Frasers Putney Stage 1 Phase 1 - Response to Public Submissions

**Building Height Control Diagram**

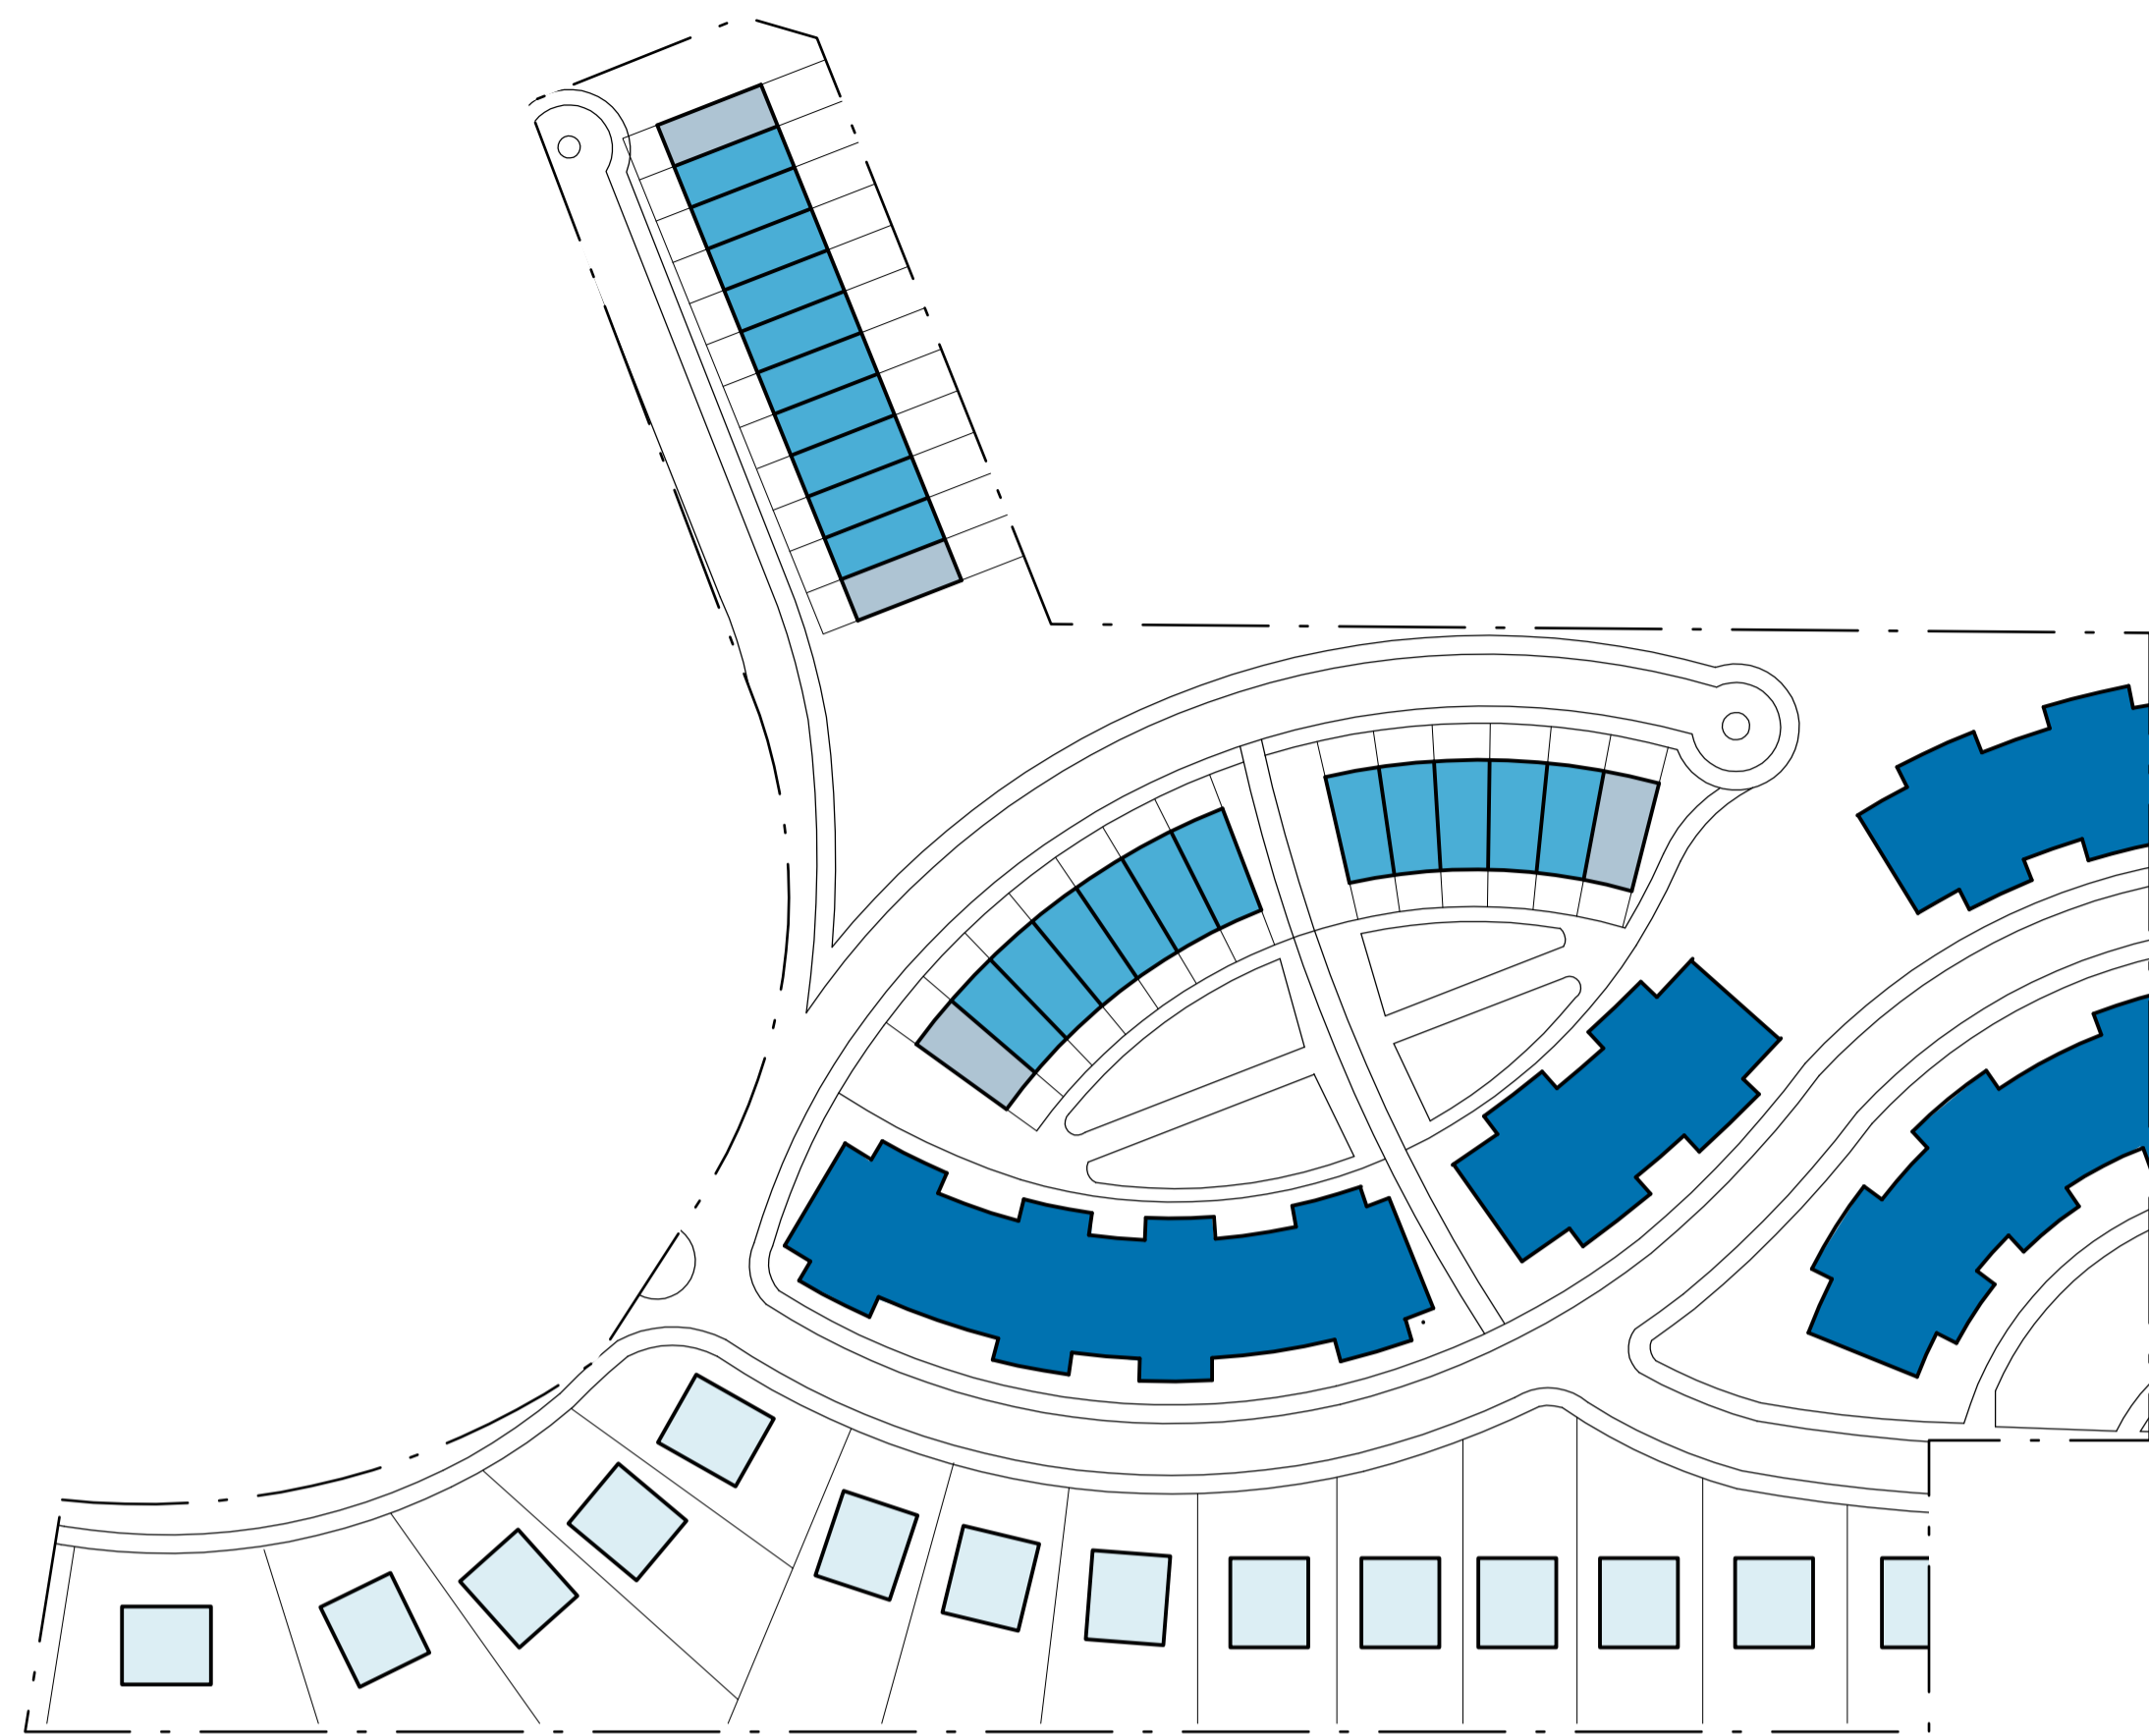
58.	The former Royal Rehabilitation Centre, Ryde site should be limited to a maximum height of two storeys with pitched tile roof construction as approved by the City of Ryde Council.	The Stage 1 Phase 1 Project Application provides for a range of dwelling types and heights including detached houses, townhouses and residential flat buildings which are consistent with the approved Concept Plan (MP 05_0001) for the site.

DWG FILE: X:\104479 - Putney Hill Residential Development - Stage 05 - Stage 1A\104479-05-MIE04-104.dwg - MHPLOT TIME: 13 Dec 2011, 2:46pm

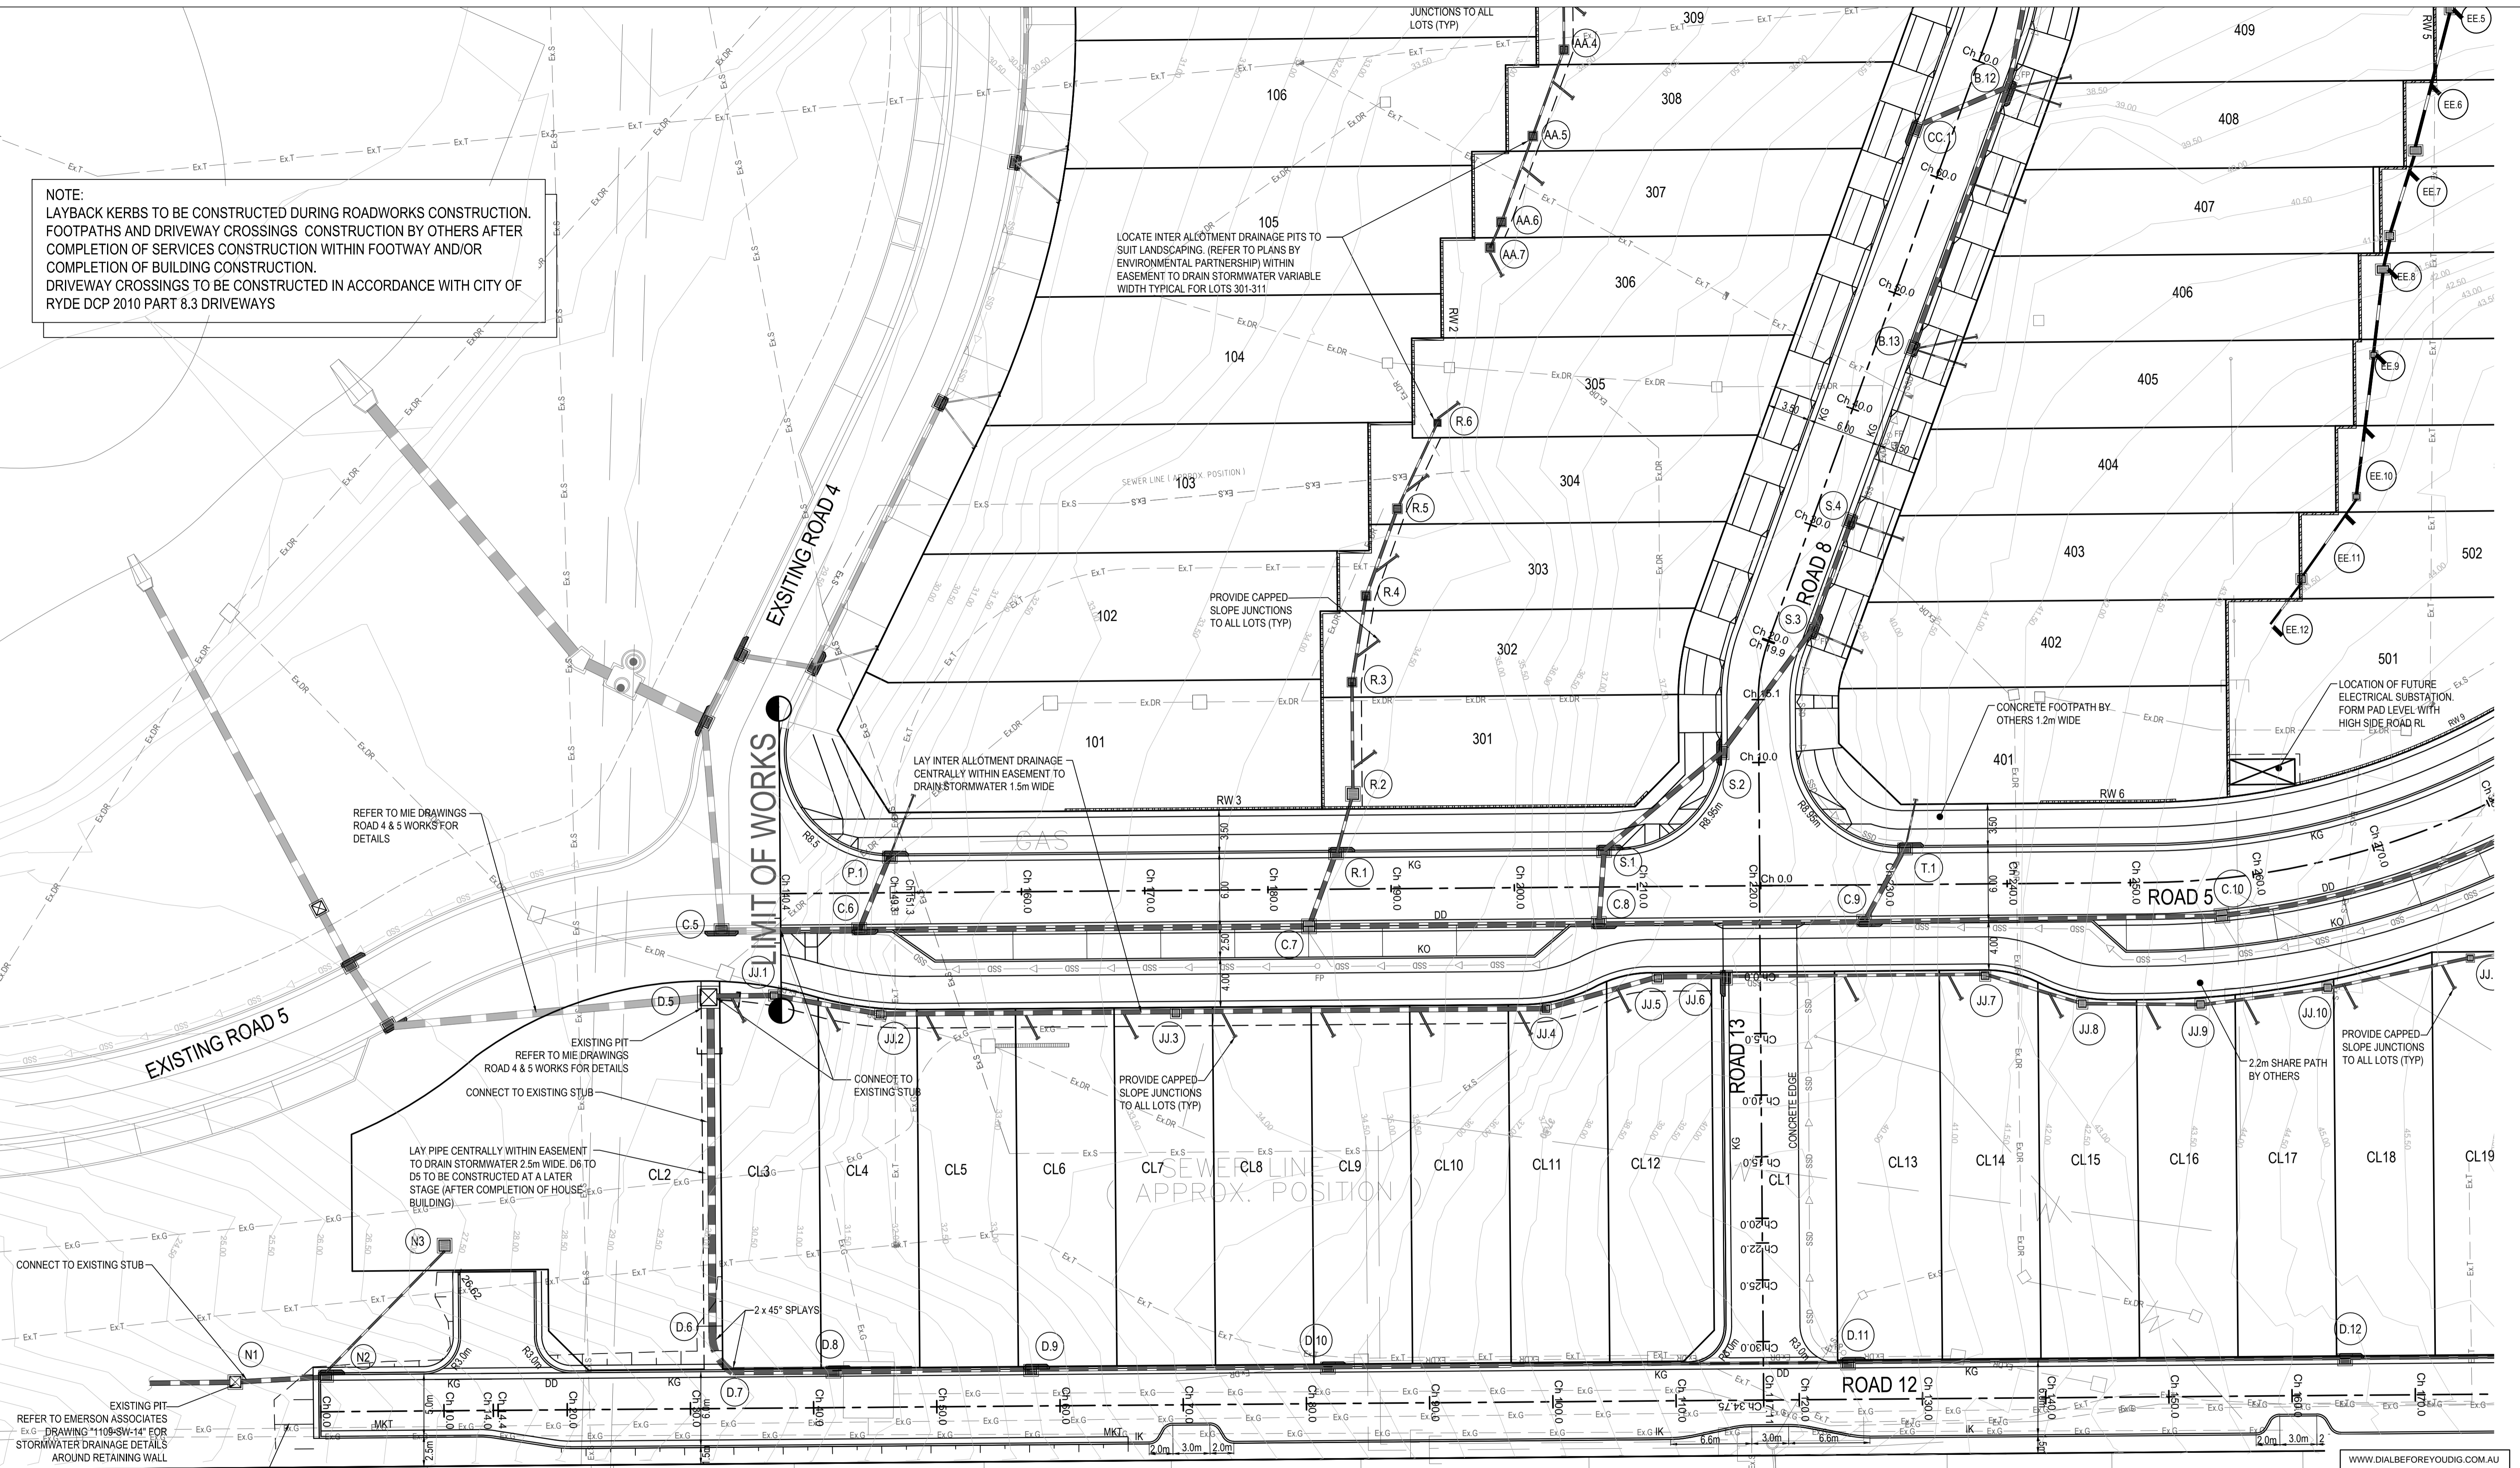
30.	Traffic entering the site should do so by way of a deceleration lane beginning from the intersection of Charles Street and Victoria Road.	A deceleration lane is proposed to be provided within the site’s frontage to Victoria Road, as show in the Civil Drawing MIE44. The design of this deceleration lane satisfies the relevant design and construction requirements of Ausroads and the relevant RTA supplements.
7 Kenneth Street Residents (8 properties)
